Our Case Number: ABP-313892-22

Re: Bus Connects Blanchardstown to City Centre Core Bus Corridor Scheme
Blanchardstown to Dublin City Centre

Blanchardstown to City Centre Core Bus Corridor Response (Case: 313892)

Drawing File Name
 BCIDC-ARP-TSM_GA-0005_XX_00-DR-CR-0029

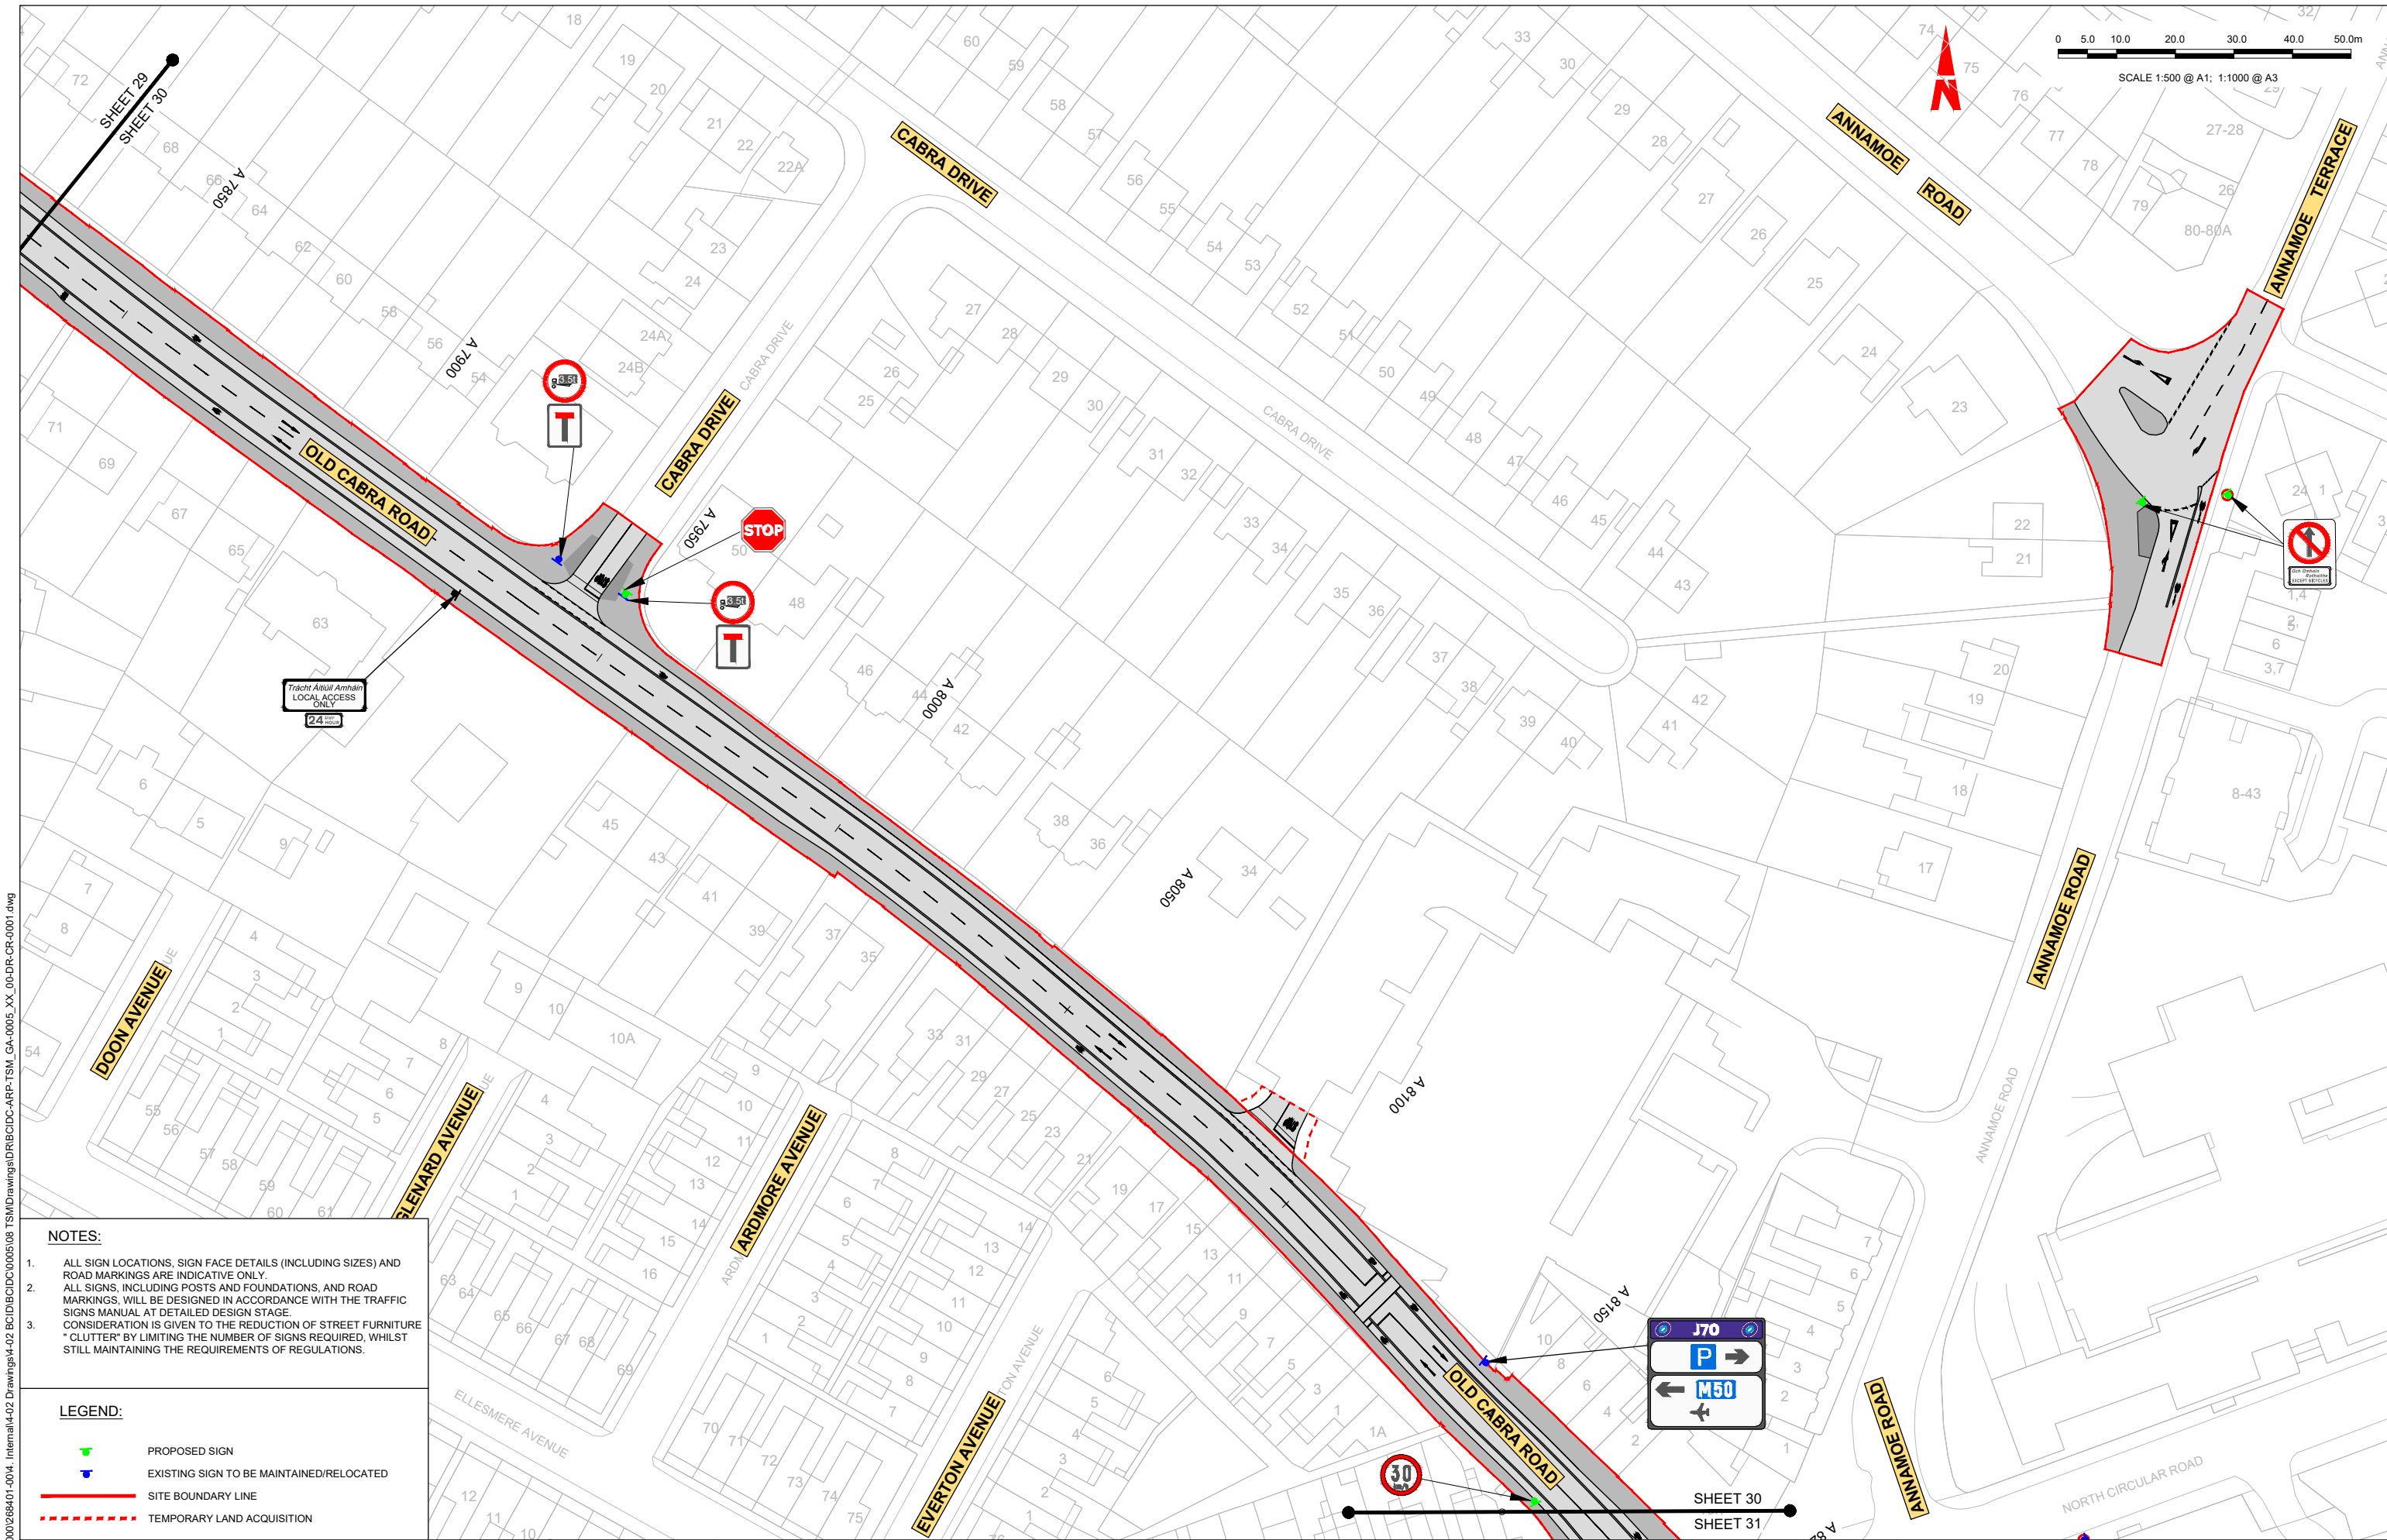
BusConnects junction design doesn't leave space for the DCC proposal to connect into this Core Bus Corridor without re-aligning the Cabra Road junction again.

The junction design proposed by the NTA for Cabra Cross doesn't take into account actively planned cycle lanes. This will leave critical gaps in the cycling network at junctions.

Our request is that the Cabra Cross junction be changed to support integration with actively planned cycle projects outside the scope of this project. The junction is within the red line boundary of this application. It is well within the power of the board to alter the design of this junction (and others) via condition.
